Rezoning Transportation Analysis

Petition Number: 2020-140

General Location Identifier: Tax ID (06904142), Rozzelles Ferry Road & Zebulon Avenue

Date	Description
10-26-20	First Review (EL)
11-30-2020	Second Review (KP)

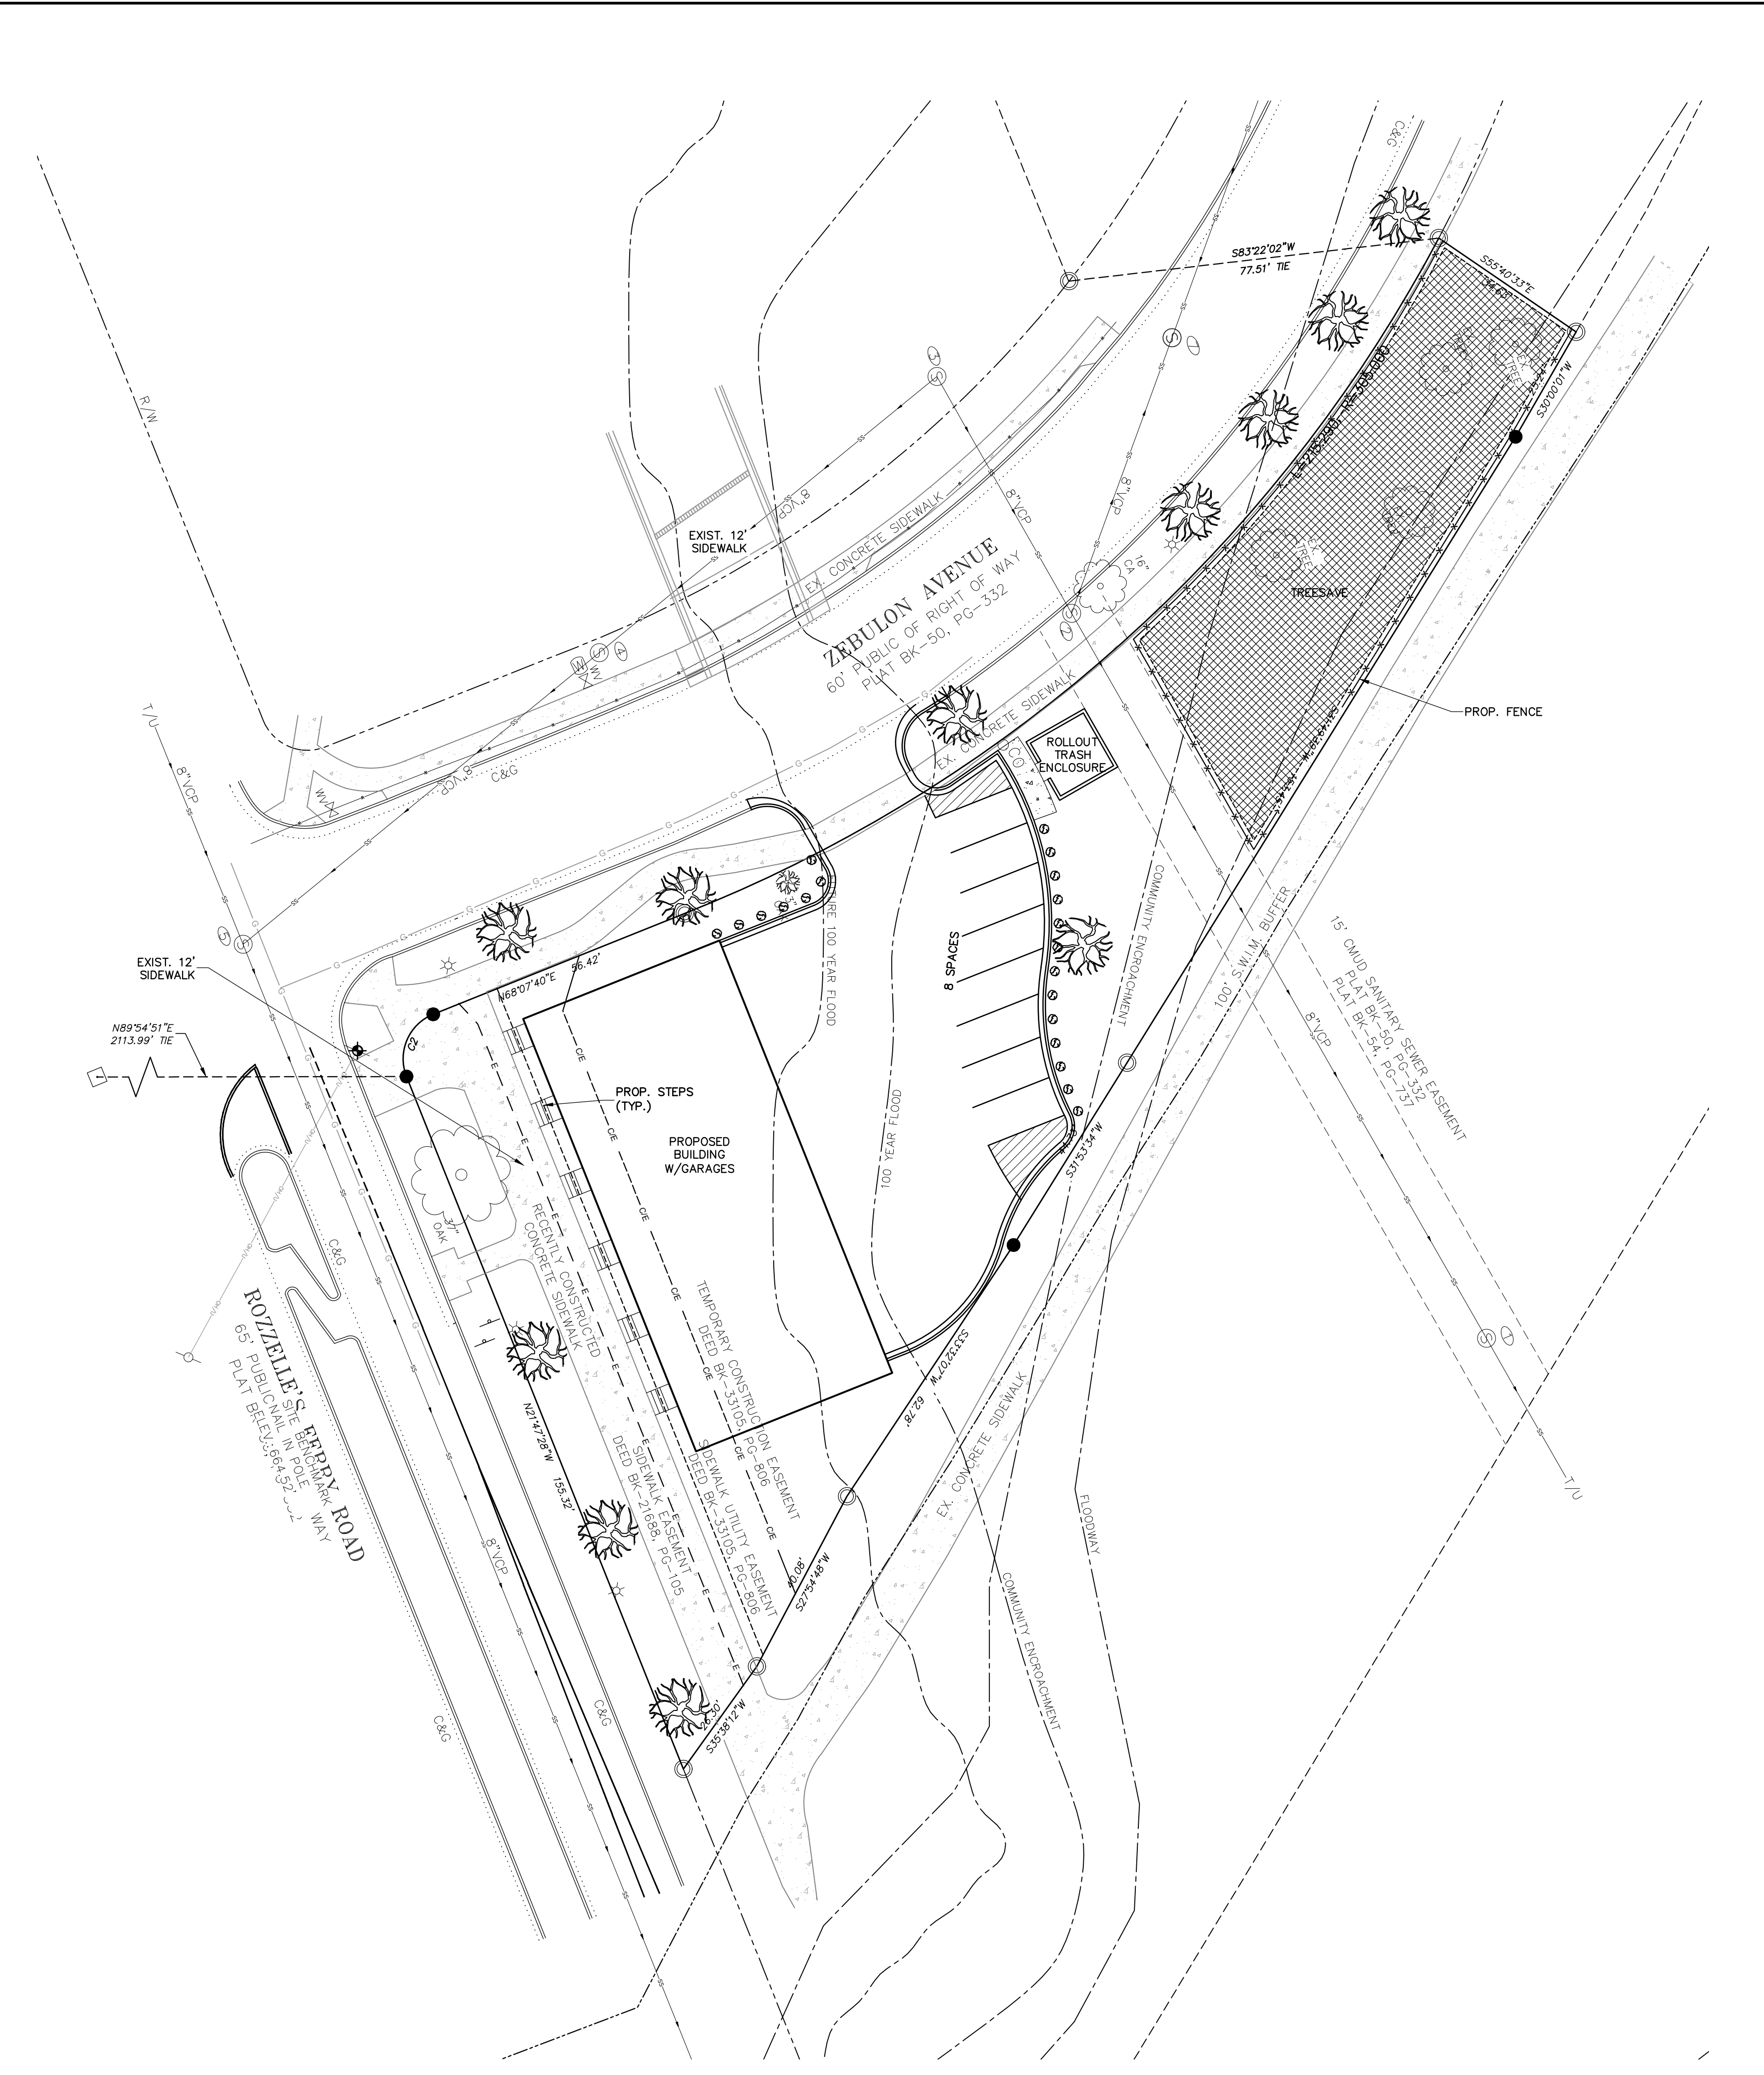
Label and dimension curb and gutter from the centerline for each road on the site plan.

- Add site plan note(s) specifying dedication and fee simple conveyance of all rights-of-way to the City before the site's first building certificate of occupancy is issued. CDOT requests rights-of-way set at 2' behind back of sidewalk where feasible.
- Add site plan note specifying that all transportation improvements will be approved and constructed before the site's first building certificate of occupancy is issued. The petitioner may phase transportation improvements if said improvements and phasing are explicitly described in site plan notes.
